Letter No. B2/6708/2000

Dated: 11-5-2000

Sub: CMDA - Area Plans Unit - Planning Permission  
Proposed construction of 2 Blocks of Bank-  
cum-residential building with 12 Dwelling Unit  
at T.S.No.23, Block No.30 of Kottur village  
in Door No.7, Gandhi Nagar Ist Main Road,  
Adyar, Chennai -20 - Development charge Advice  
sent - Regarding.

SITE PLAN

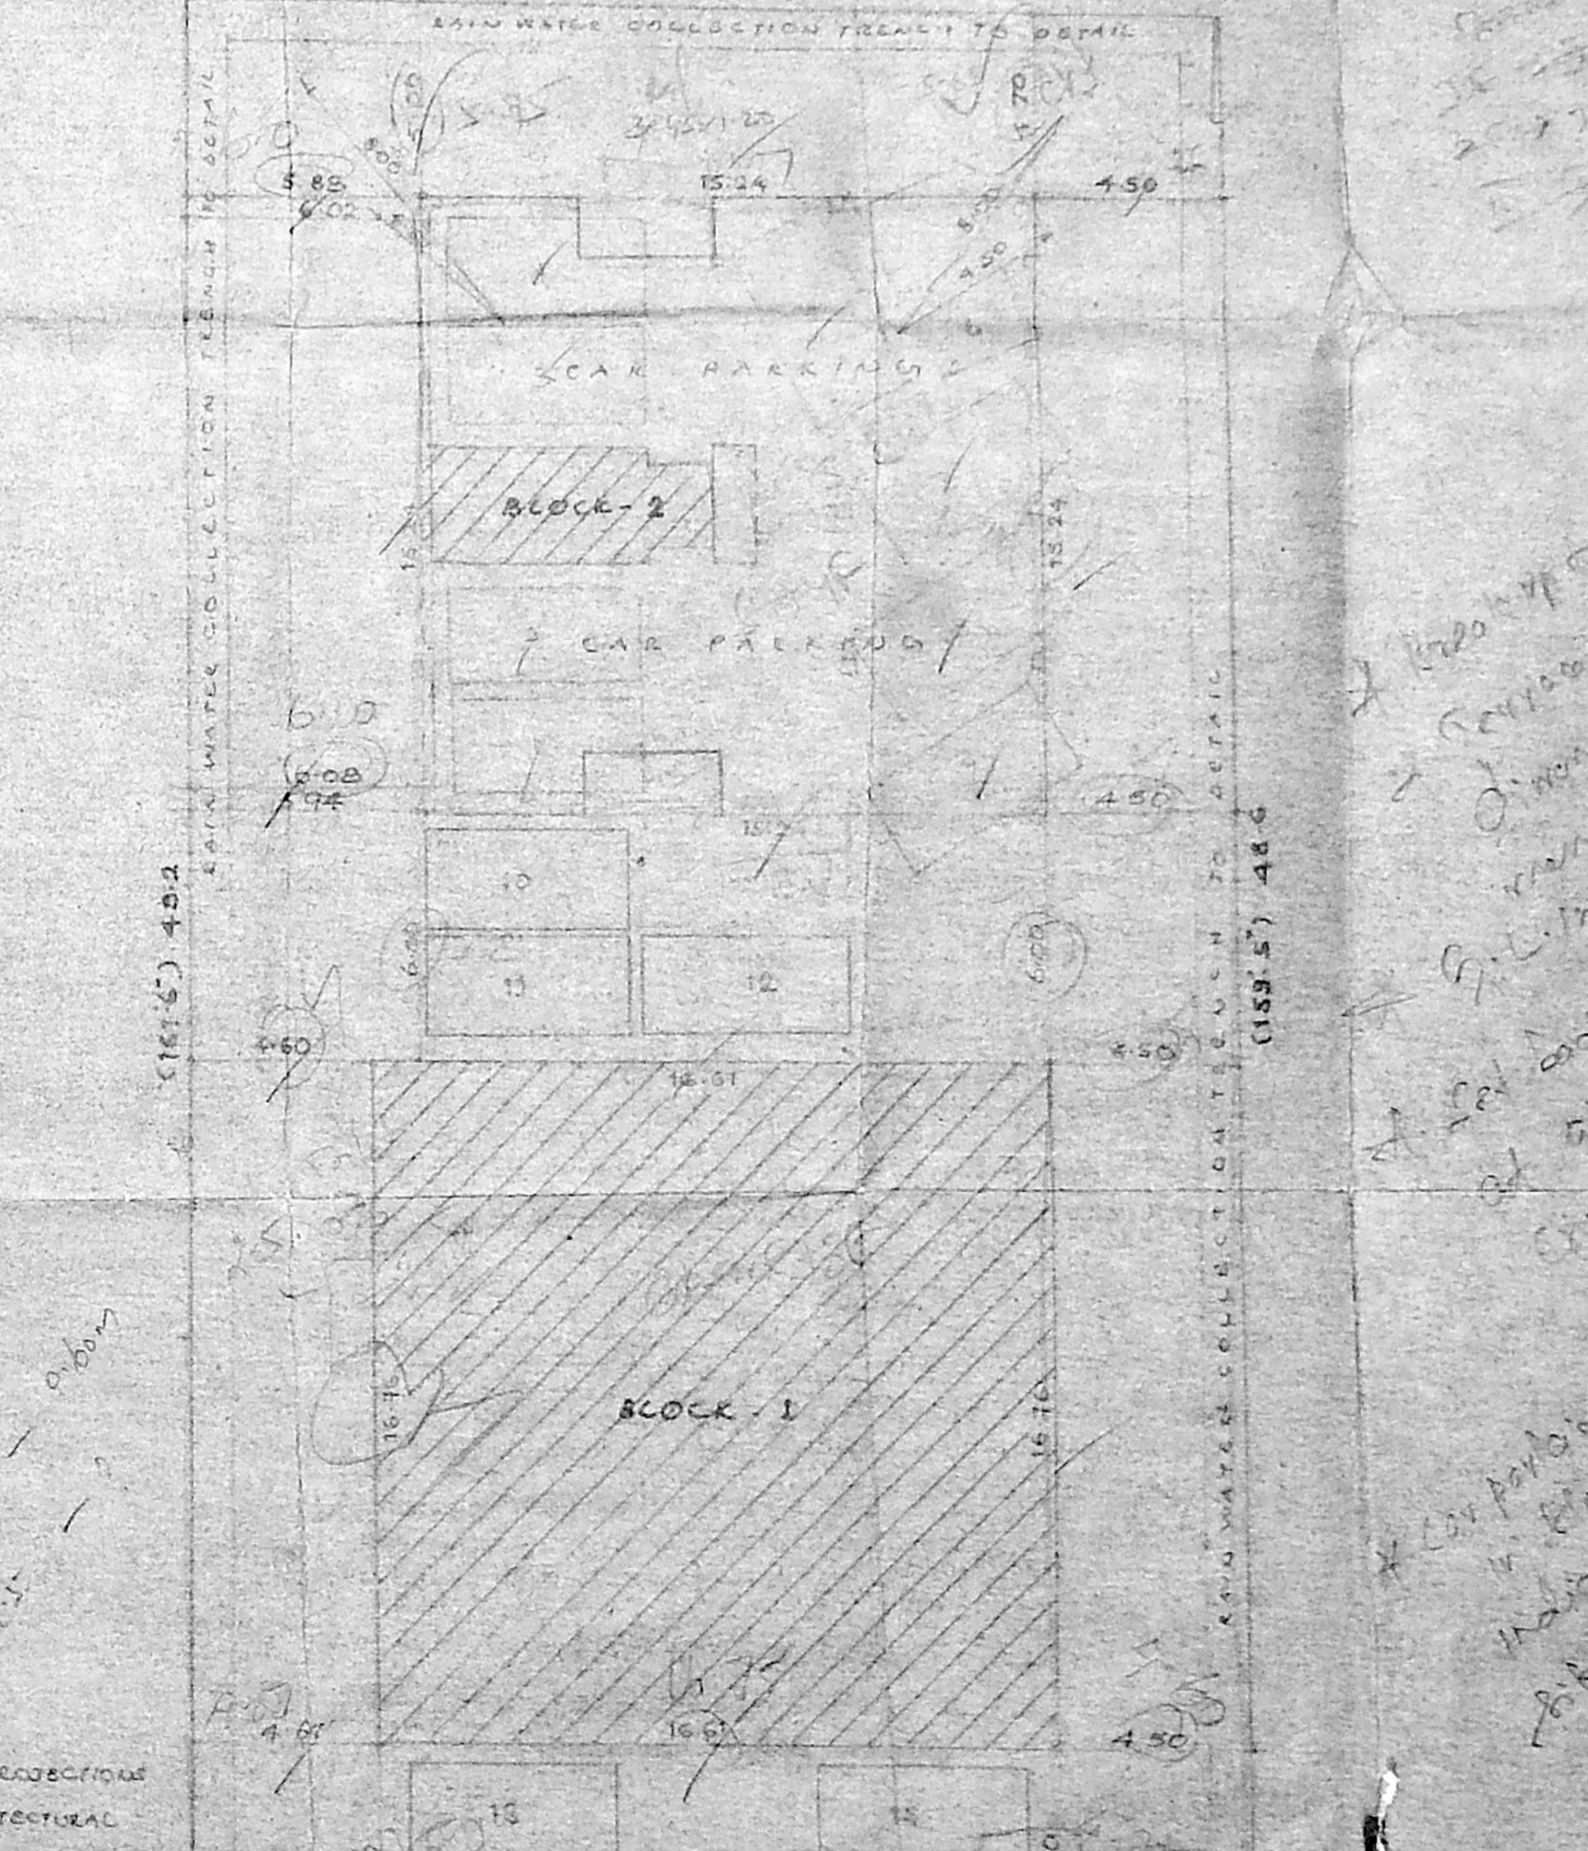
- \*\* a) Tallying the Break-up measurements to its total
- b) Mention the set back measurement at all the Crucial points
- c) Rearranging the parking lots in the stilt floor in conformity with DCR
- d) Showing the parking arrangement in the site plan
- e) Mention the building measurements in the terrace floor
- f) Correcting the section and elevation for Block -II
- g) Marking the Ground level in the section and elevation
- ii. Attested copy of Chennai Corporation sanctioned demolition plan for the structures existing in the site under reference.
- iii. Front elevation and section 'BB' Tallying with reference to floating columns.
